**STATEMENT OF ENVIRONMENTAL EFFECTS: SECTION 75W APPLICATION, MODIFICATIONS
TO MAJOR PROJECT MP NO.10_0158 (BUILDINGS 7 & 8) – 61 MOBBS LANE, EPPING**

Pursuant to Section 75W (1) (a) of the Environmental Planning and Assessment Act 1979, a 'modification of approval' is sought to vary Condition No. A2 pertaining to Major Project MP No. 10_01581 (Buildings 7 & 8) as approved on the 12 July 2011. The modification is to amend architectural plans to accommodate minor design changes.

A7101A
PROJECT
APPLICATION

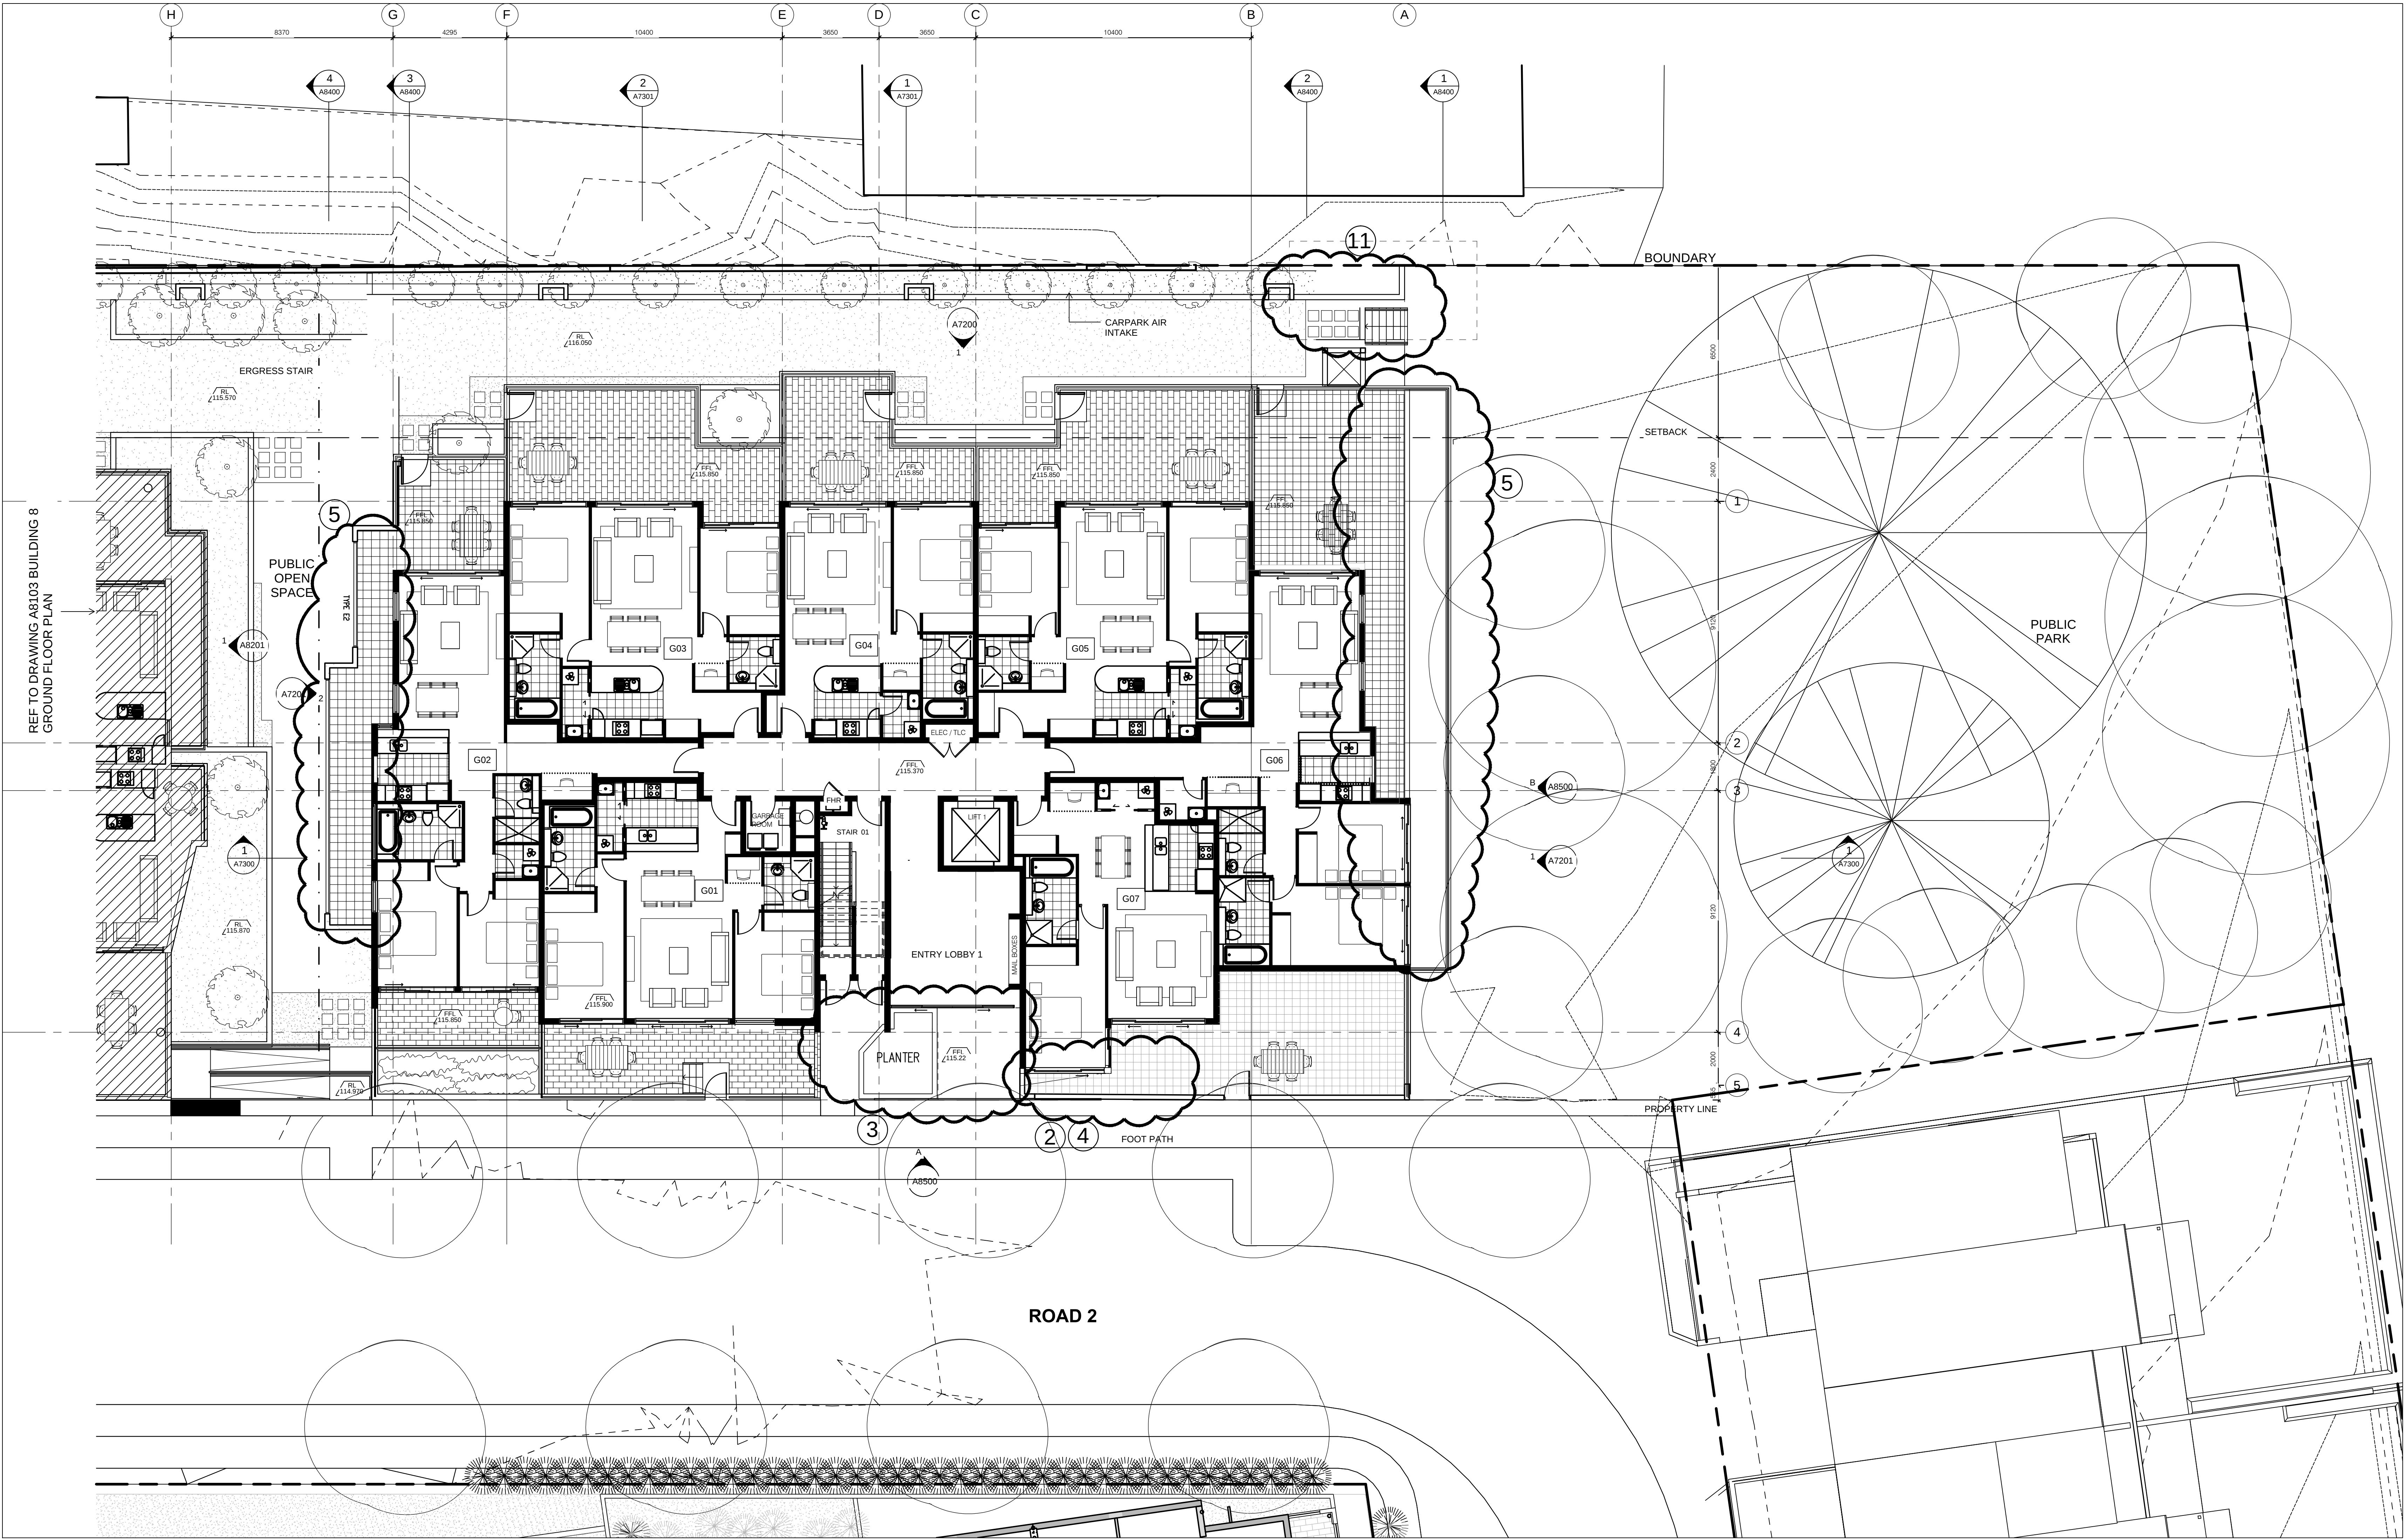
Building 7 Existing Approval	Building 7 Proposed Modification (Numbering as per the legend on the submitted plans)
Ground Floor Plan, A7101	Ground Floor Plan, A7101, Rev A 2. Wall removed 3. Modification of unit 4. Courtyard standardised 5. Courtyard extended 11. Carpark egress removed
B7 Elevations, A7200	B7 Elevations, A7200, Rev A 8. Reconfiguration of courtyard fence
Building 8 Existing Approval	Building 8 Proposed Modification
Ground Floor Plan, A8103	Ground Floor Plan A8103, Rev A 1. NIB removed 2. Wall removed 3. Modification to Unit 4. Courtyards standardised 5. Extension of courtyard
Level 1 & 2 Plan, A8104	Level 1 & 2 Plan, A8104, Rev A 3. Modification to unit 6. Window removed
Level 3 & 4 Plan, A8105	Level 3 & 4 Plan, A8105 Rev A 6. Window Removed 7. Reconfiguration of louvre screens
Level 5 & 6 Roof Plan, A8106	Level 5 & 6 Roof Plan, A8106 Rev A 6. Window Removed 7. Reconfiguration of louvre screens
